# **OXFORDSHIRE COUNTY COUNCIL'S RESPONSE TO CONSULTATION ON THE FOLLOWING DEVELOPMENT PROPOSAL**

**Application no:** 17/01542/REM

**Proposal:** Reserved Matters to 17/00559/F - Phase 1 of Oxford Technology Park including details of siting, design, layout and external appearances of units referred to as 1 and 3.

**Location:** Land East Of Evenlode Crescent And South Of Langford Lane, Kidlington.

Oxford Technology Park  
 Cycle Shelter Details

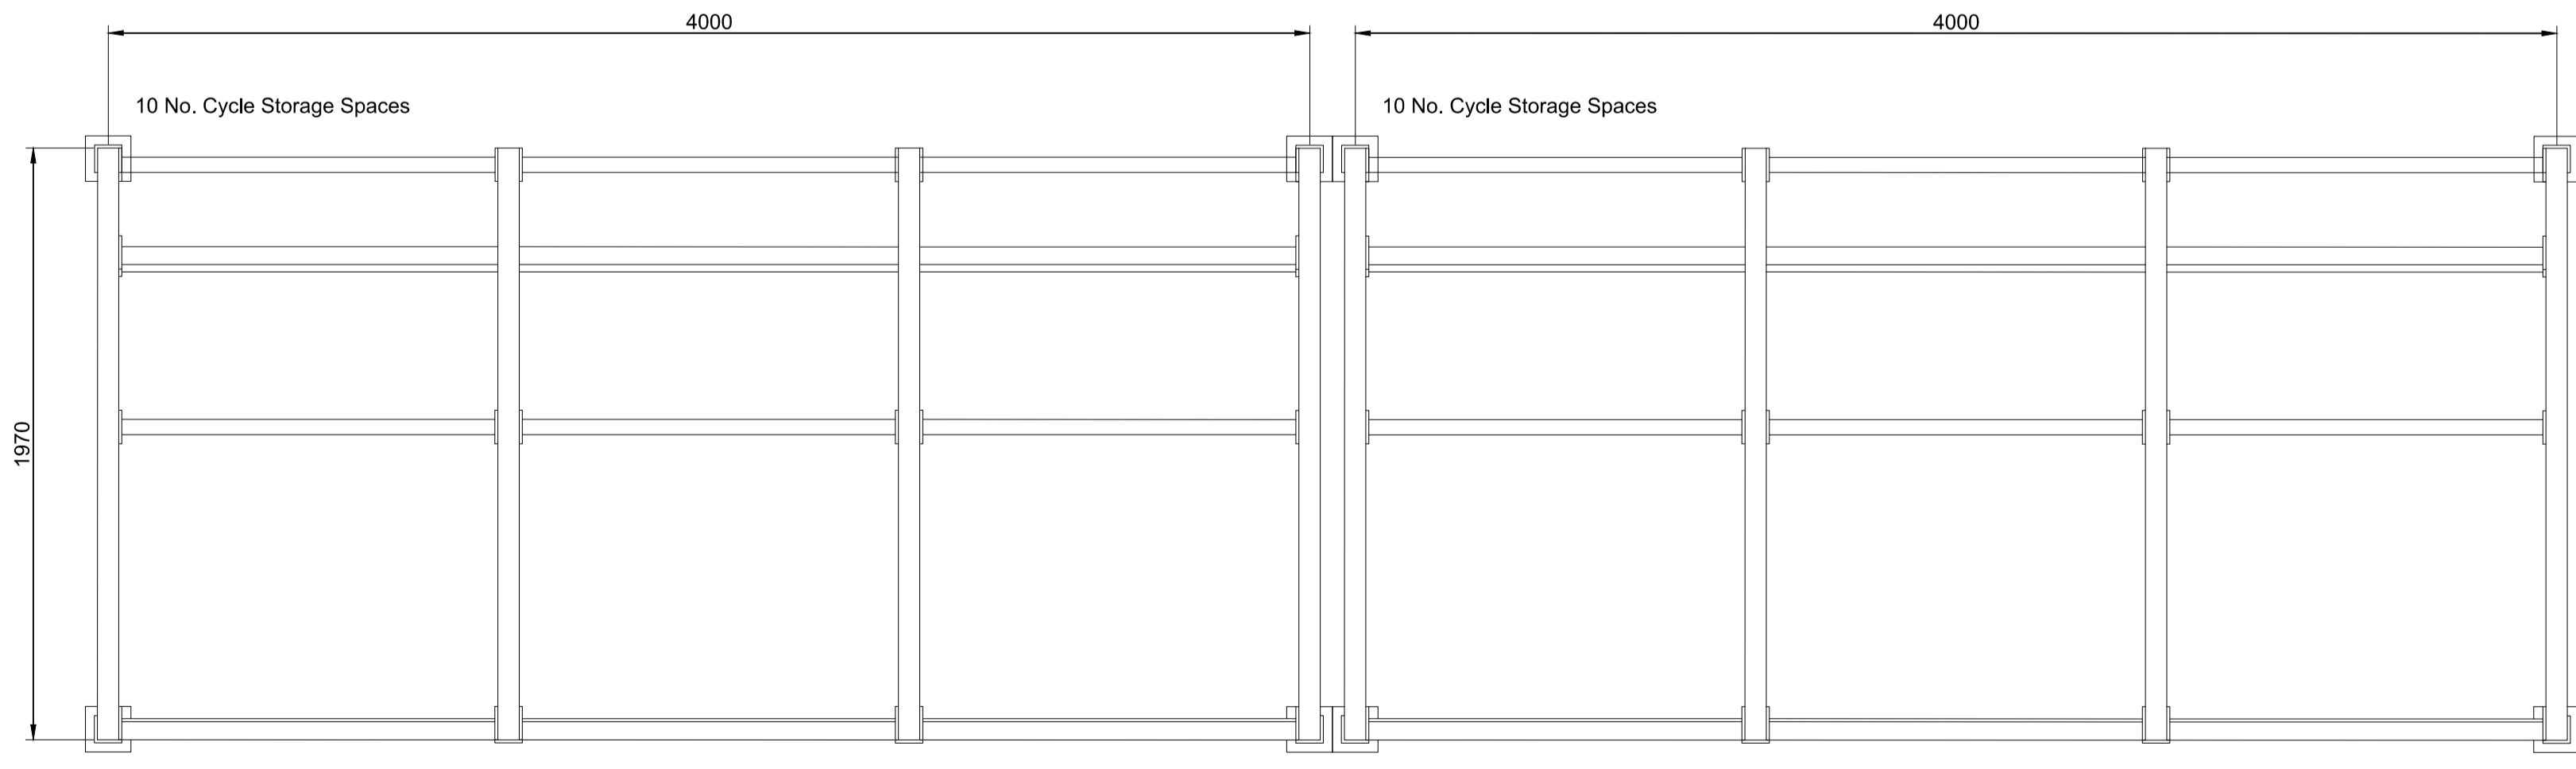
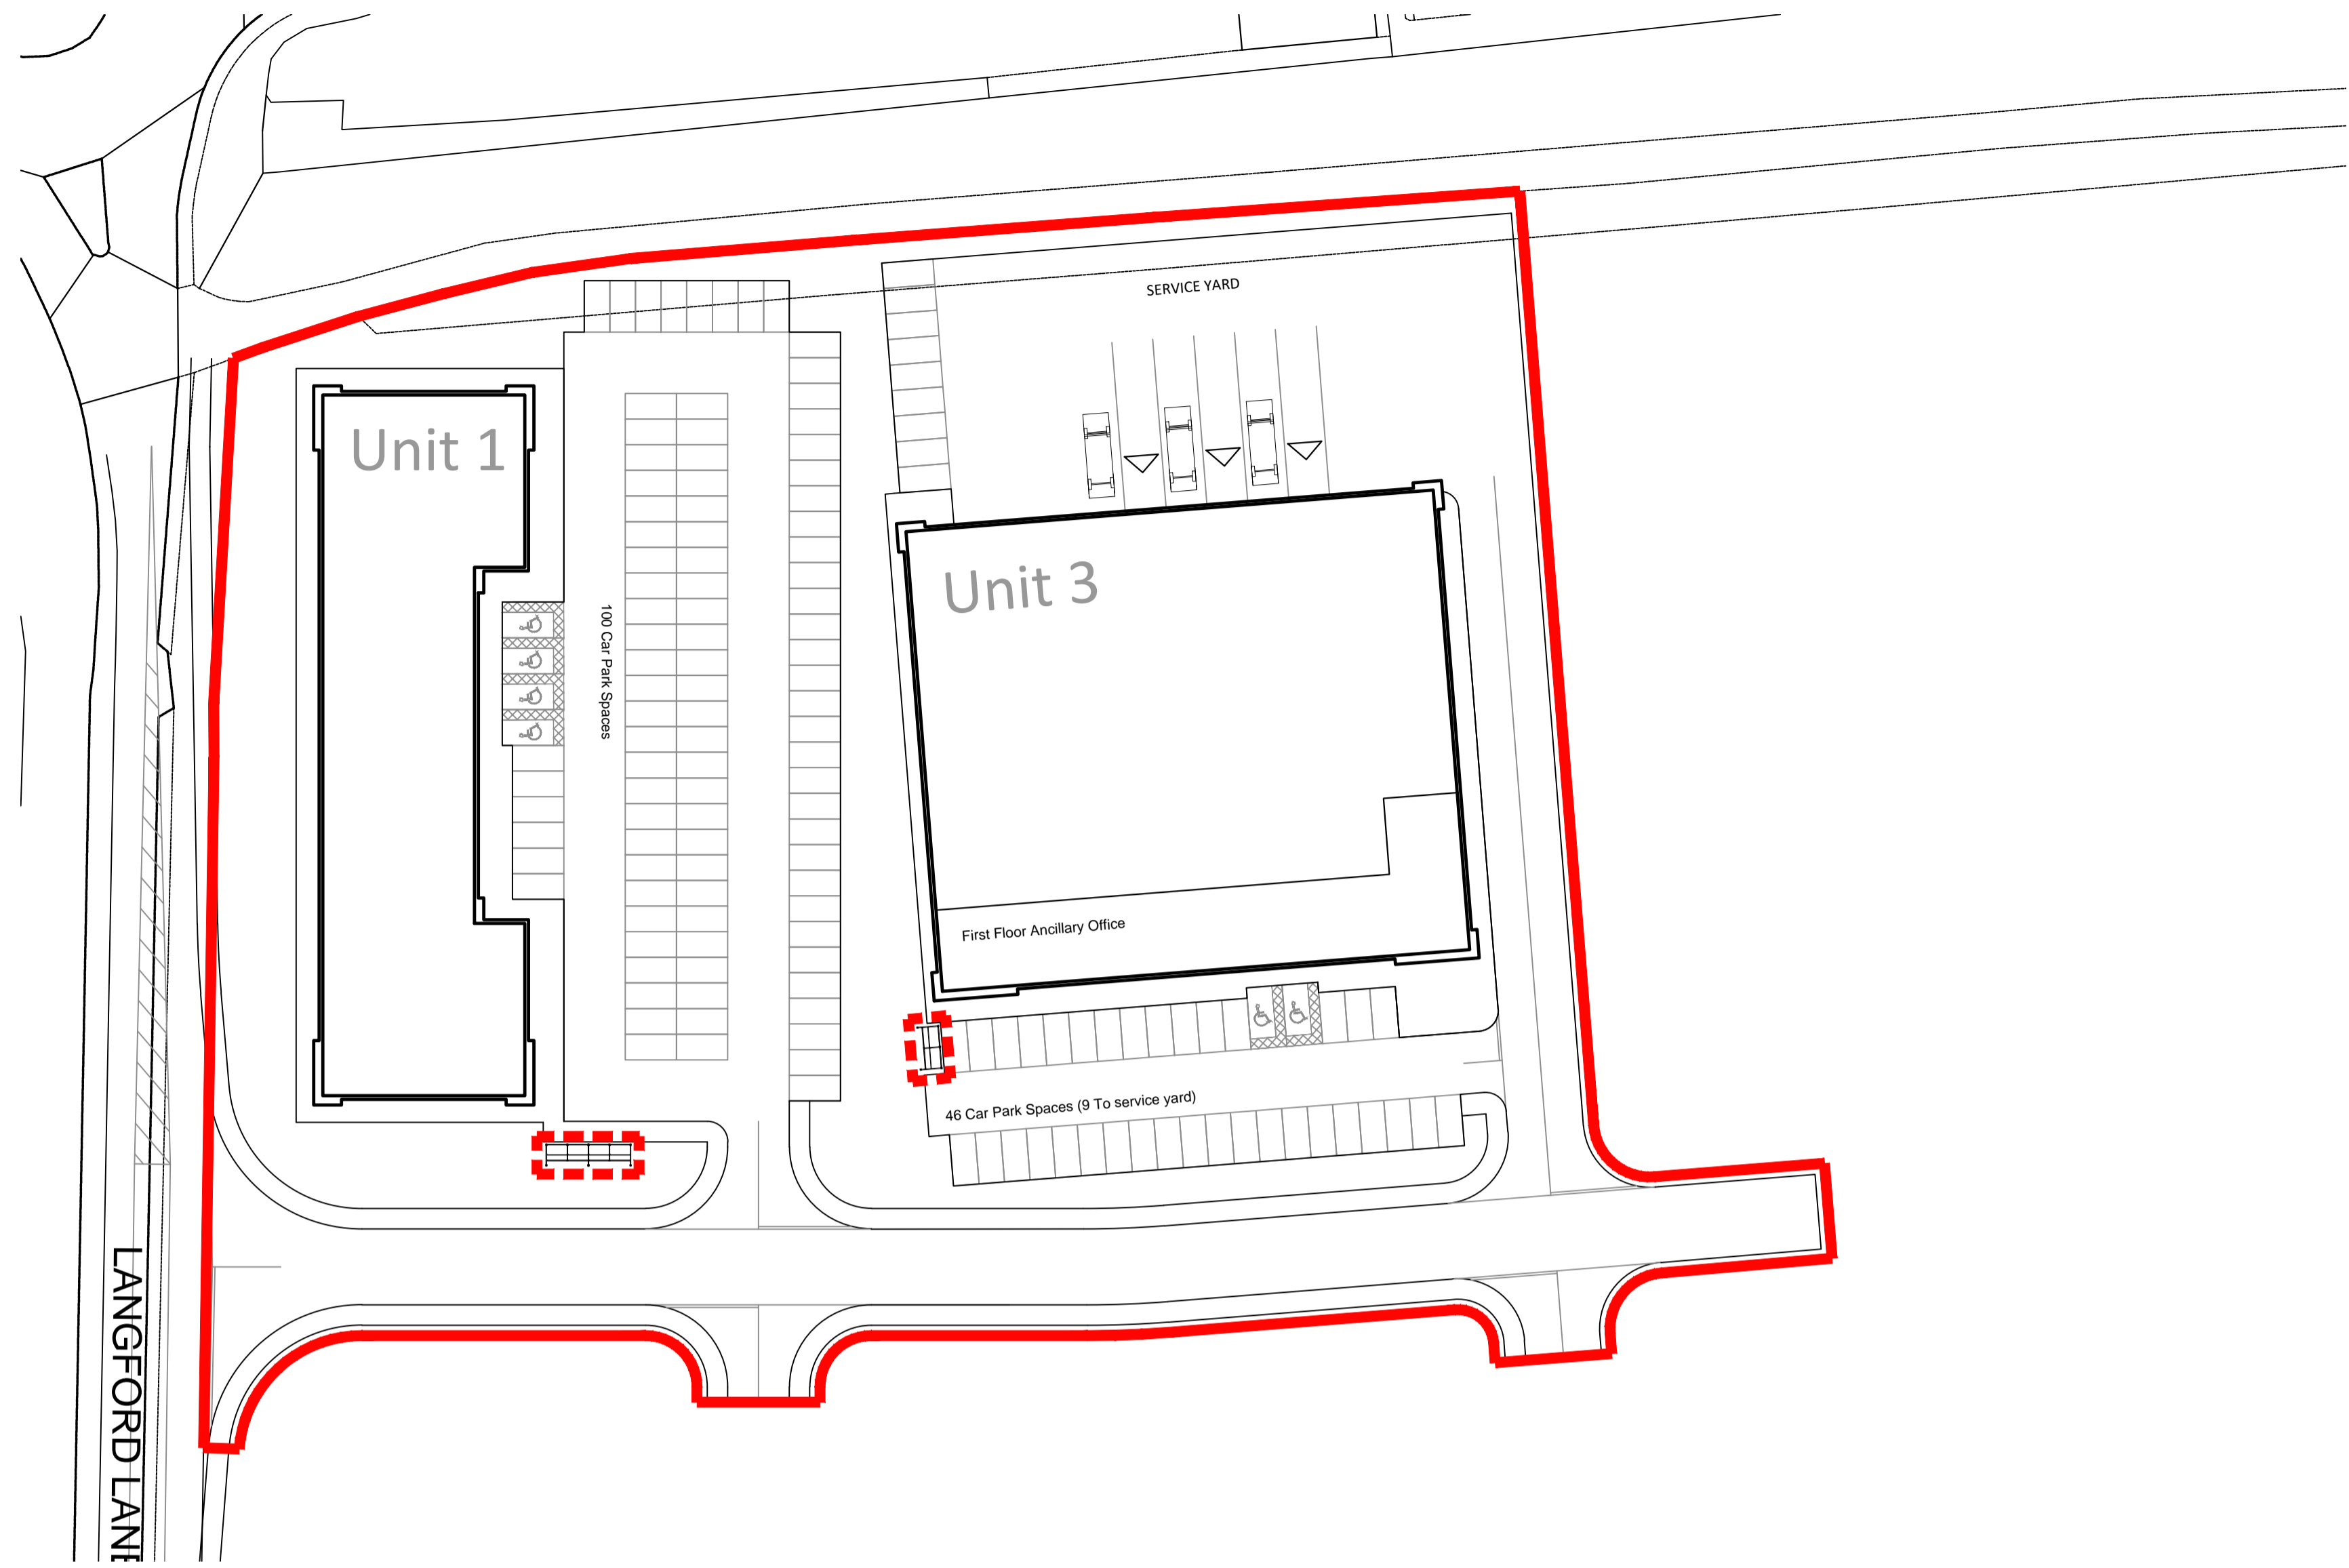
The applicant has provided five covered Sheffield stands for each site, which can accommodate up to 10 bicycles each. The buildings are 3796m<sup>2</sup> and 2779m<sup>2</sup> of B1 (a) and B (b) office space respectively. Going by Oxfordshire County Council's current minimum cycle parking standards, plot 1 would have to provide a minimum of 25 cycle parking spaces for employees, plus an additional 8 for visitors, and plot 3 would have to provide 19 employee cycle parking spaces plus 6 for visitors. Although there is no existing cycle facility on Langford Lane, there are reasonable cycle links from Kidlington, Oxford and Woodstock to the development so I think the applicant needs to provide more cycle parking spaces to make cycling to and from the site an attractive prospect, and reduce the amount of single occupancy car trips on the local road network during the AM and PM peaks.

Prior to the commencement of development, a plan showing the proposed cycle parking for plots 1 and 3 of the proposed development should be submitted to and approved in writing by the Local Planning Authority. Thereafter, construction shall only commence in accordance with the approved details.
